## DRAINAGE INFORMATION SHEET

PROJECT TITLE: DOUBLE RAINBOW ZONE ATLAS/DRNG. FILE #: F/21 / D.60  
DRB #: \_\_\_\_\_ EPC #: \_\_\_\_\_ WORK ORDER #: 4890.90  
LEGAL DESCRIPTION: LOT 11, MONTGOMERY BUSINESS PARK  
CITY ADDRESS: JUANTABO BLVD NE  
ENGINEERING FIRM: JEFF MORTENSEN & ASSOC. CONTACT: JEFF MORTENSEN  
ADDRESS: 6010 B MIDWAY PARK BLVD NE PHONE: 345-4250  
OWNER: BERNSTEIN'S CONTACT: CONTRACTOR  
ADDRESS: \_\_\_\_\_ PHONE: \_\_\_\_\_  
ARCHITECT: ED FITZGERALD CONTACT: SAME  
ADDRESS: 2225 LEAD SF. PHONE: 268 9055  
SURVEYOR: BERNIE SEITZ CONTACT: SAME  
ADDRESS: \_\_\_\_\_ PHONE: \_\_\_\_\_  
CONTRACTOR: KLINSEN CONSTRUCTION CONTACT: RAY SMITH  
ADDRESS: 8701 WASHINGTON AVE PHONE: 822-9990

RE: ENGINEER CERTIFICATION FOR TEMPORARY CERTIFICATE OF  
OCCUPANCY RELEASE, @ DOUBLE RAINBOW (F21-D60)  
CERTIFICATION STATEMENT DATED 1/27/95.

JEFF MORTENSEN & ASSOCIATES, INC.  
6010-B MIDWAY PARK BLVD. N.E.  
ALBUQUERQUE, NEW MEXICO 87109  
ENGINEERS & SURVEYORS (505)345-4250**GRADING AND DRAINAGE PLAN****DOUBLE RAINBOW BAKERY & CAFE**

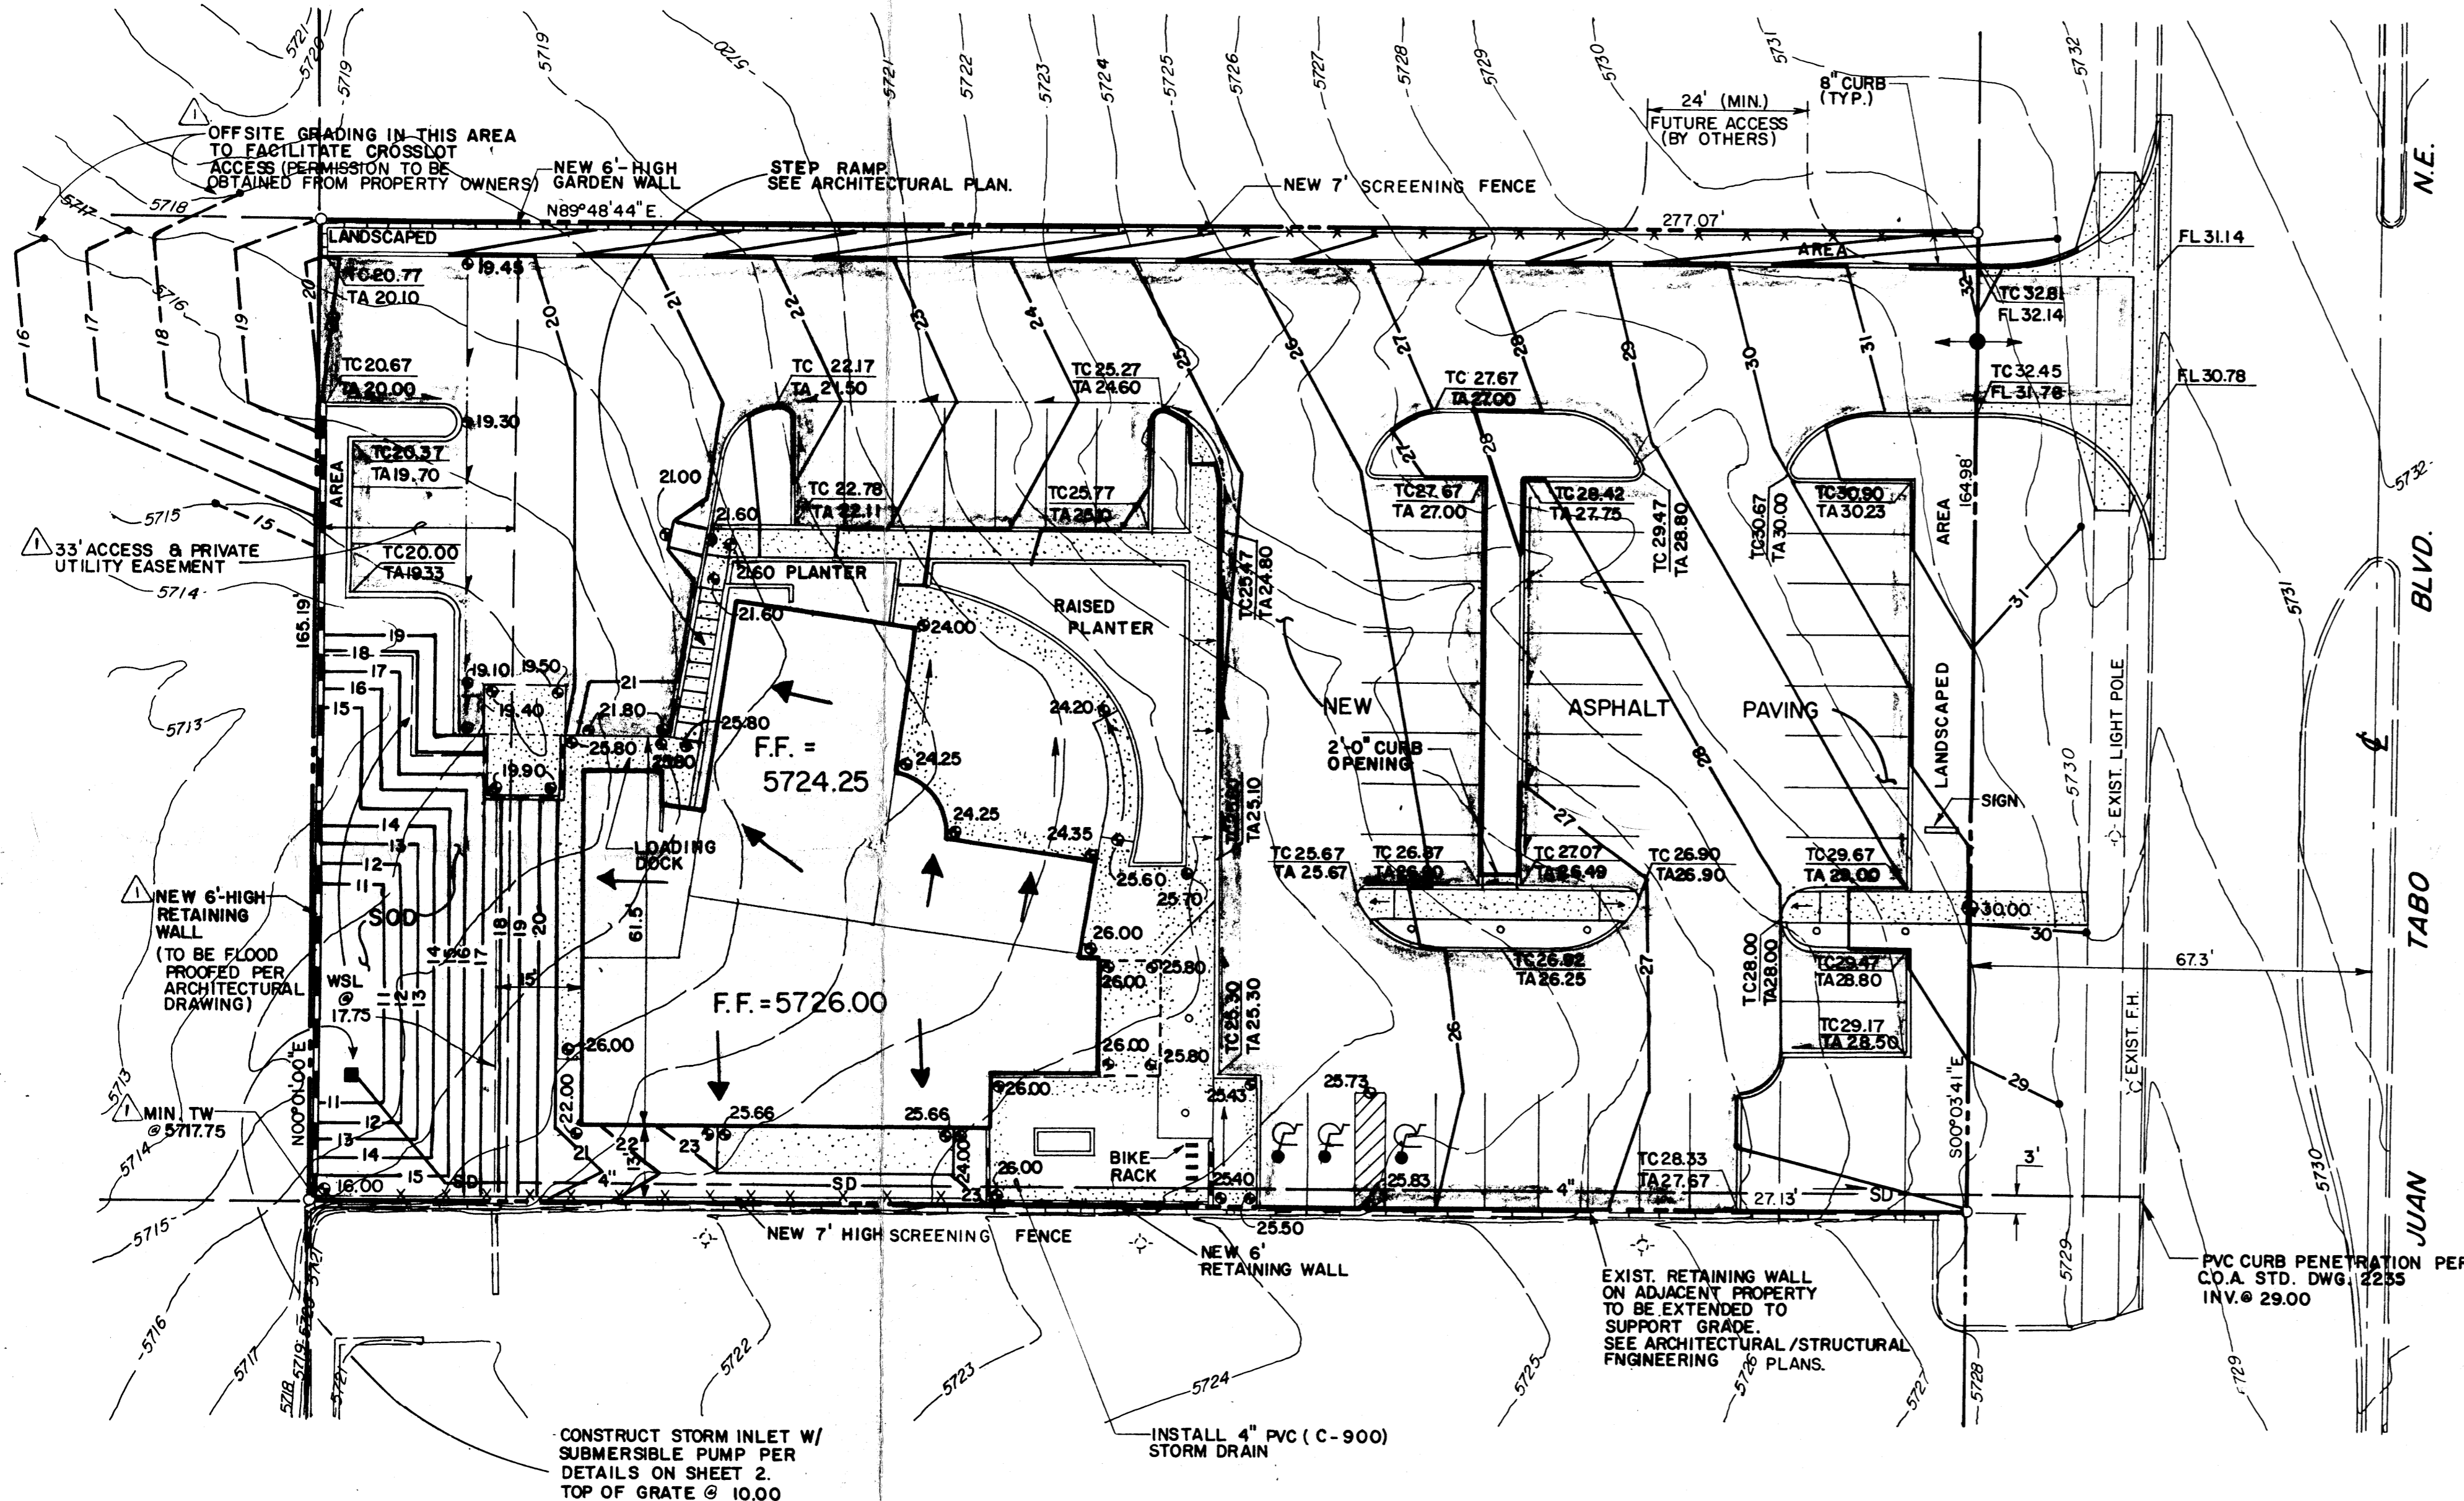
Please be advised that prior to Certificate of Occupancy release, Engineer Certification per the D.P.M. checklist is required. Keep in mind that the water proofing of the walls adjacent to the ponding area is critical and must be a part of the Engineer Certification.

1. Cross section for the proposed pond indicating how you propose to flood proof the adjacent property to the west. Item No. 1 on my letter dated 1/13/93.
- ✓ 2. Recommend that you interconnect all the roof drains and outlet them into the bottom of the pond. If you don't use this concept then identify erosion protection on all the slopes of the pond.
- ✓ 3. Your original plan indicated that there was a 33' foot private access and utility easement within the proposed ponding area. What happened to the easement and why is it not shown on the new plan?
- ✓ 4. Recommend that you compute your required volume using the hydrograph method from the new hydrology criteria.
- ✓ 5. Review and approval of this plan does not approve the future off-site grading, unless concurrence is provided from the adjacent property owner.

The north and south private access and utility easements were vacated on August, 1984 per Vacation No. V-84-77. The east private utility and access easement never existed. Private access and utility easement still exists and has now been shown on the Grading and Drainage Plan.

SUBMERSIBLE PUMP DETAILS &amp; SECTIONS

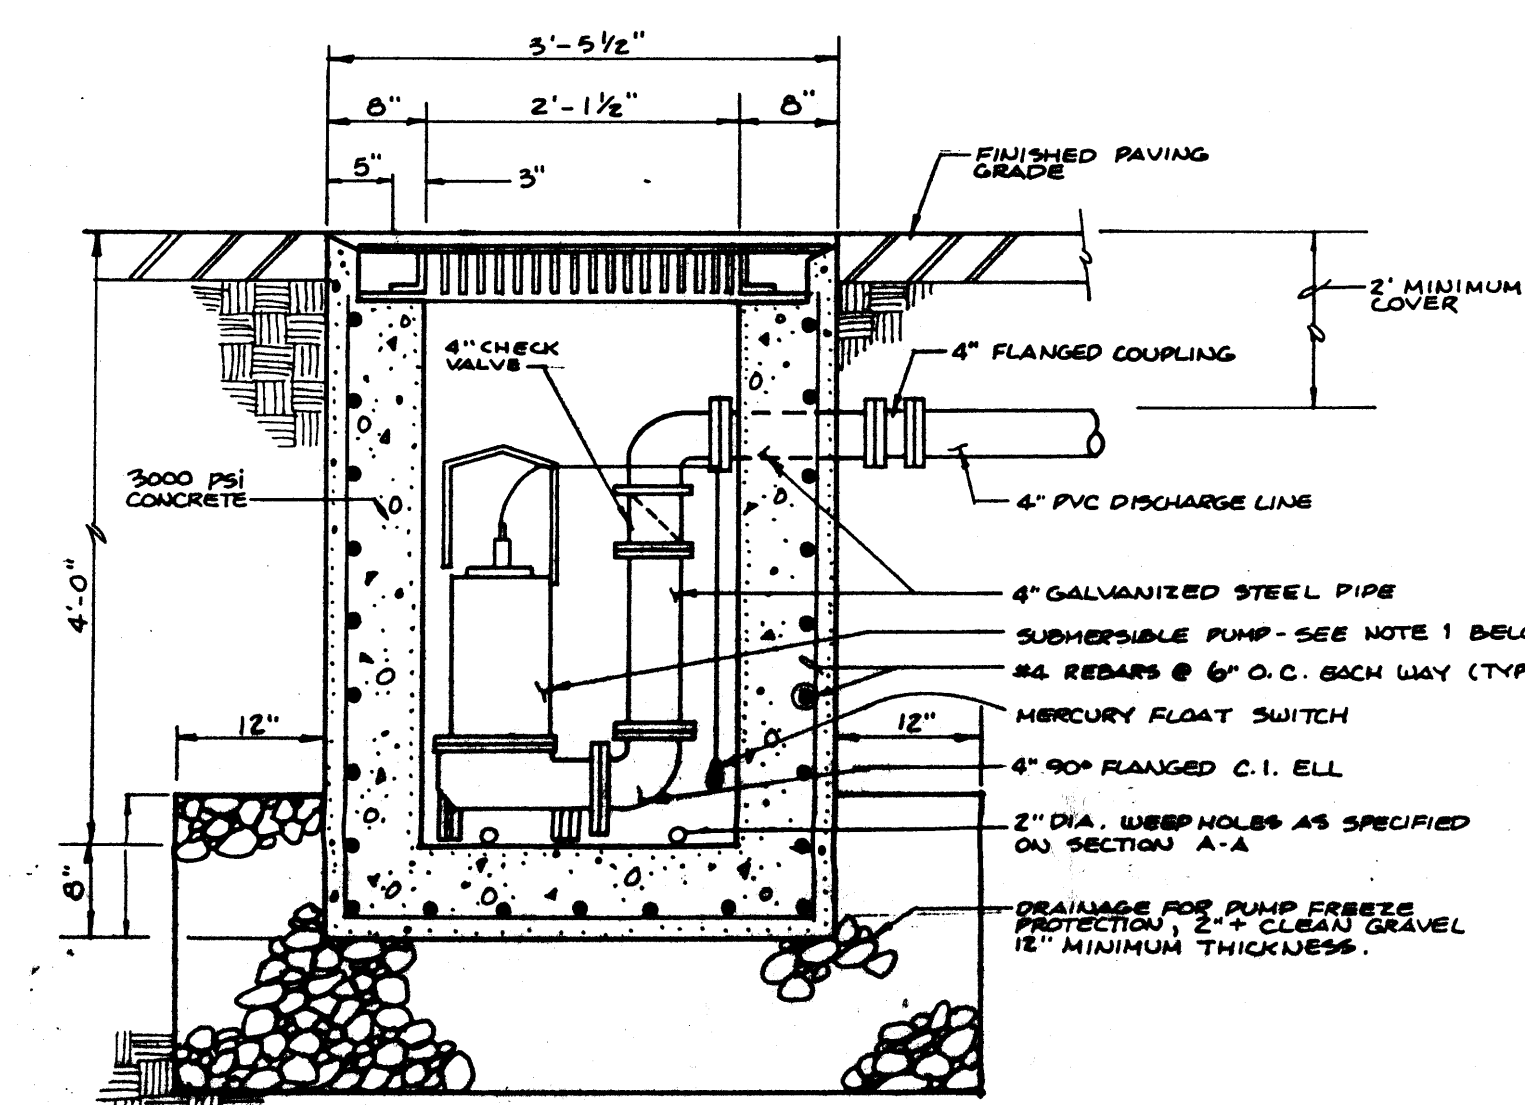
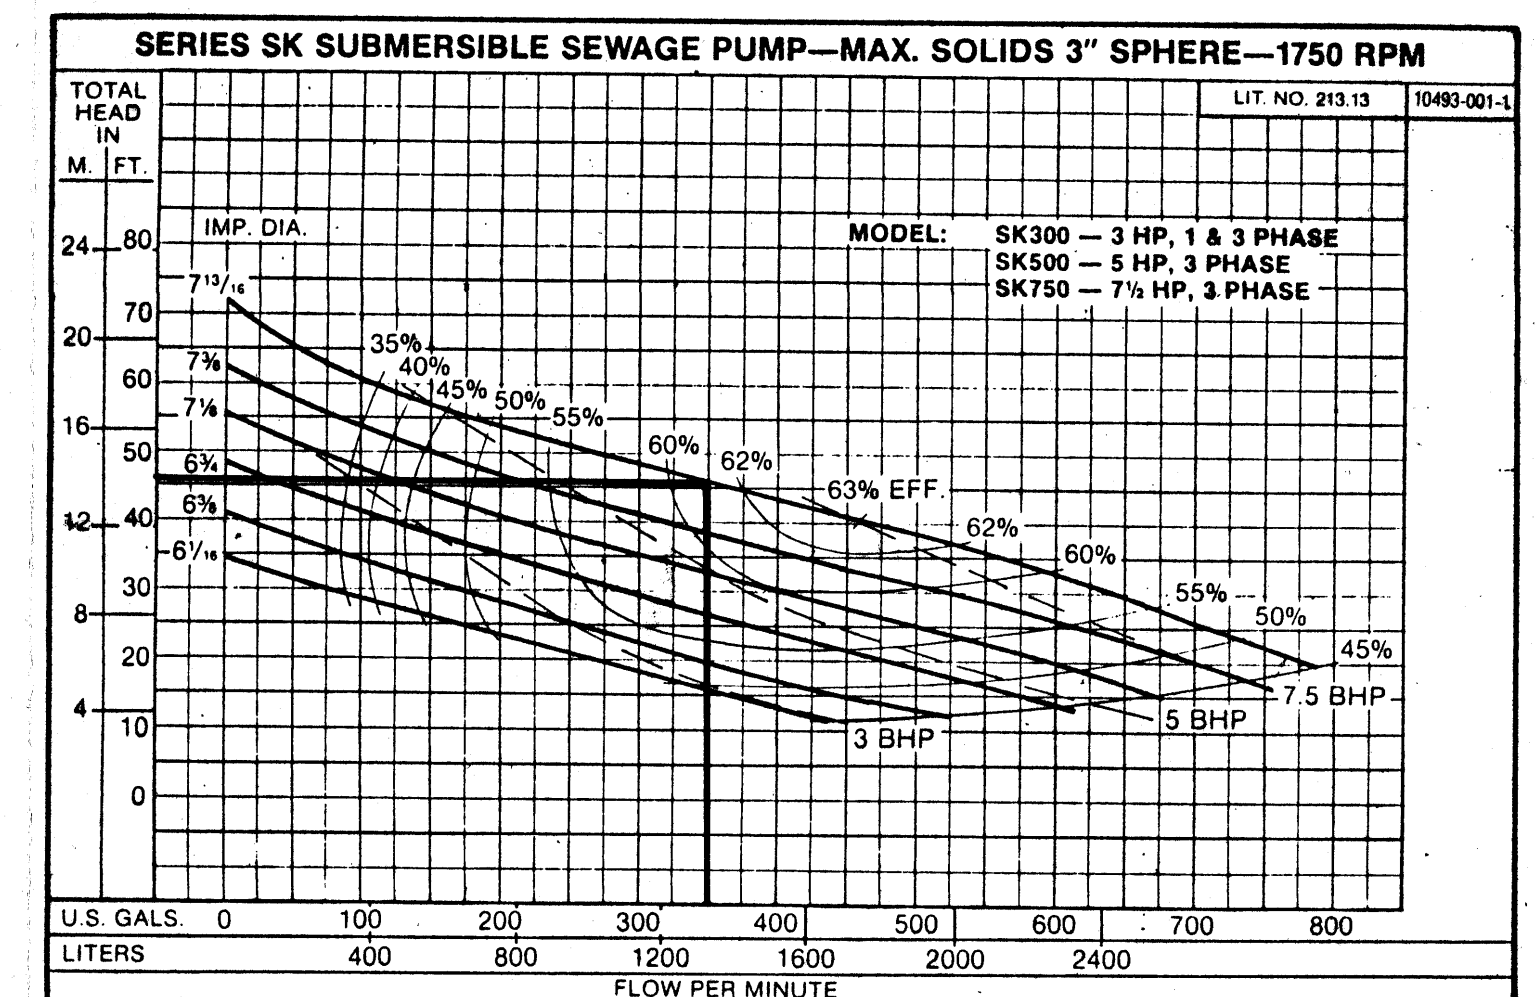
- ? 1. If you can not meet the requirements for the ponding adjacent to the proposed building and adjacent properties, you must include a section describing how you propose to water proof the building footings and also the adjacent property walls.
